**Consultation Response from KC,  
Highways Development Management**

**2025/93438 Arena Young Peoples Centre, Moorlands Road, Dewsbury, WF13 2LF**

**Erection of 10-unit (class C2) special needs care home, day centre (class E(f), administration and training building (class E(g)(i)**

**Date Responded: 16/03/2026**

Appendix 3 – Fire Tender Swept Path Analysis

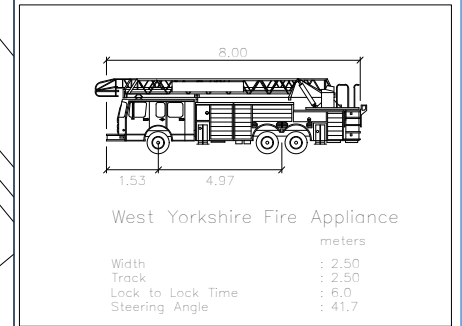
A turning head is provided on site that is suitable for vehicles up to mini-bus size and drawing number 6695 T1 01 rev 0 shows that an 8m West Yorkshire Fire and Rescue fire tender can turn on site and this is acceptable. Refuse vehicles would not be expected to enter the site and turn and so a bin collection presentation point has been located adjacent to Boothroyd Lane and this is acceptable to the Kirklees Waste Strategy team. Again, we would need to see a swept path analysis that indicates that an 11.85m refuse truck can service the site and safely turn within the entrance of the site with the possibility of cars parked on Boothroyd Lane in the event that the TRO to restrict parking is unsuccessful.
